The Member-Secretary
Chennai Metropolitan Develop-
ment Authority
1, Gandhi Irwin Road
Egmore
Chennai 600 008

Letter No. A2/34979/2004

Sub: **CMDA - Planning Permission & Construction of Ground Floor & First Floor Residential building with single dwelling unit at Plot No.9B, Balaji Nagar in S.No.410 part of Nerikundram village - Development charges and other charges to be remitted - Reg.**

PLAN OF TERRACE FLOOR

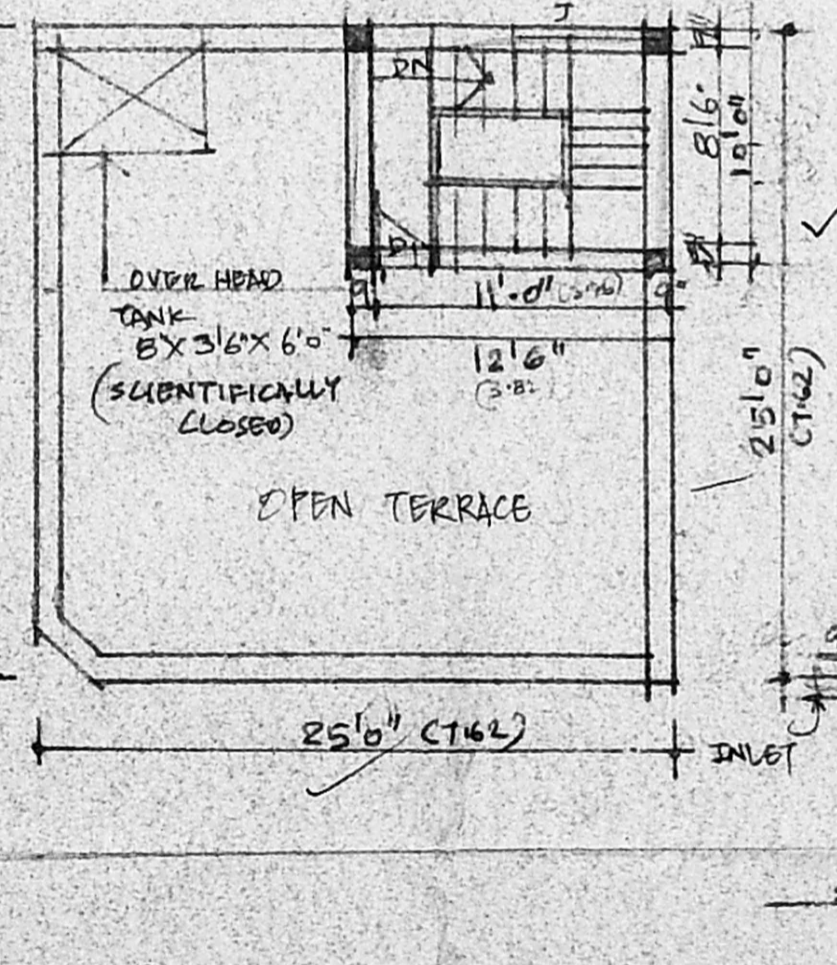
- i) by mentioning the outer measurement for balcony.
 - ii) showing the outer building measurement for terrace floor.
 - iii) Providing 7.50 cm height dwarf wall along the gate.
- c. 'B' form and checklist duly signed by N.C. Ravi.
